3 February 2012

GRAHAM BROOKS
AND ASSOCIATES
ARCHITECTS
PLANNERS AND
HERITAGE
CONSULTANTS

MP10_0097 MOD 1
Spectator Precinct Royal Randwick
Section 75W Application
Response to Heritage Branch Comments of 30/1/2012

01 PARADE RING SECTION C-C

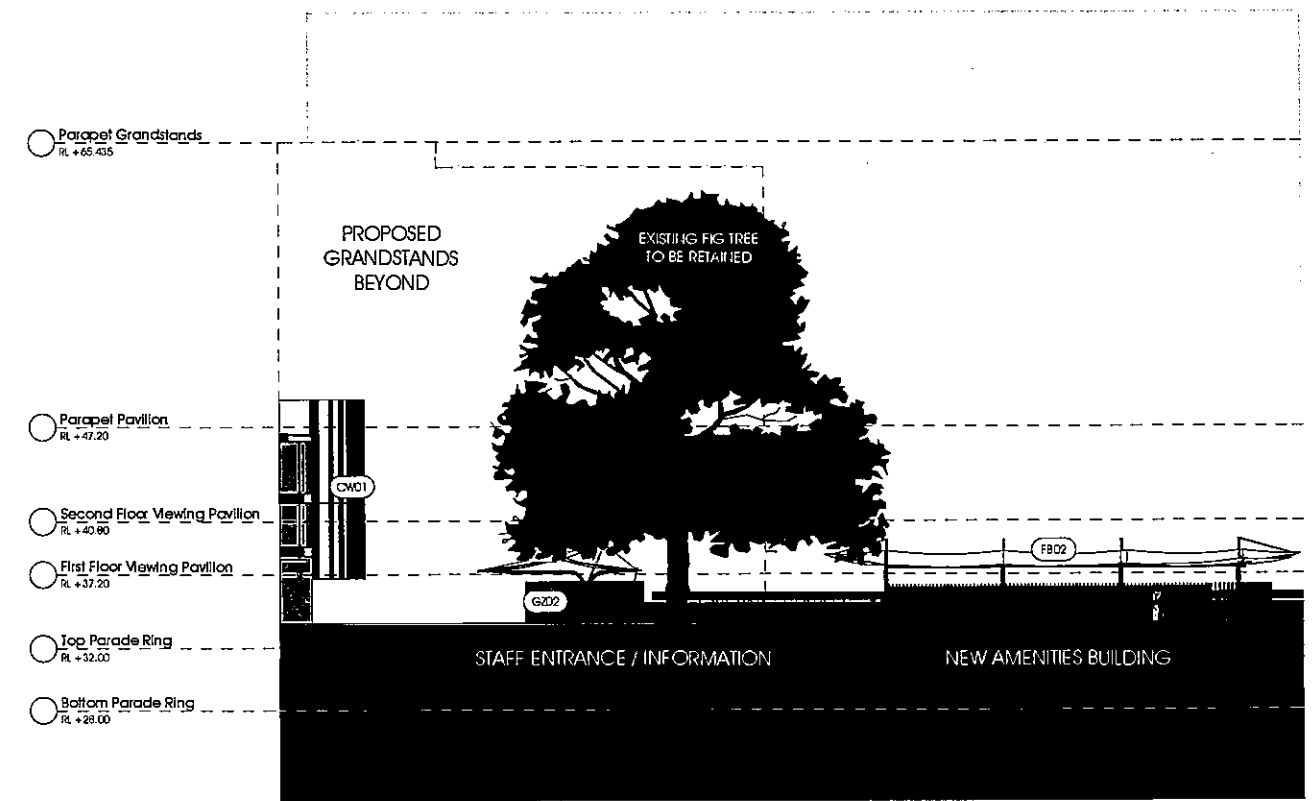
The Heritage Branch had no objection to the deletion of the proposed amenities building on the north and east of the existing day stables. In regards to the relocation of the amenities building along the north-west side of the parade ring, it was noted that the HIS did not address how this modification would affect the Tramway Turnstile Complex (which has been identified in the draft CMP for the racecourse as being an item of exceptional significance). Additional information provided by Graham Brooks & Associates indicates that the subject building is set below the level of the Spectator Precinct with only its roof visible from within the precinct. However, there is a view corridor between the bridge in front of the Tramway Turnstile Building and the Totalisator Building (assessed in the draft CMP as being of high significance).

The proposed relocation of the amenities buildings to the north-west of the parade ring appears to impact upon the view corridor between bridge and the Totalisator building. It is recommended that consideration be given to repositioning the subject buildings closer to the outer edge of the ring to reduce the intrusion of these buildings into this view corridor.

The Draft Conservation Management does not identify a specific view corridor between the bridge in front of Tramway Turnstile Building and the Totalisator building.

Figure 5.2 of the Draft Conservation Management Plan identifies 'Important Historic Views' associated with the racecourse. The only view associated with the Tramway Turnstile Building identified on this map is the view to and from the Tea House Building, which is to be removed as part of the approved development.

View 1 has been improved in changes that have been made to the Alison Road fencing since the Draft Conservation Management Plan was prepared. The approved removal of the Randwick Pavilion will reinstate View 4. The photomontage that was submitted with this application (Drawing DA-57), is View 3. It shows that the existing relationship between the Tramway Turnstile Building and the Totalisator Building is not interrupted by the relocation of the amenities buildings.

The reasons given by the Heritage Branch to support the recommendation to reposition the amenities buildings are not valid.
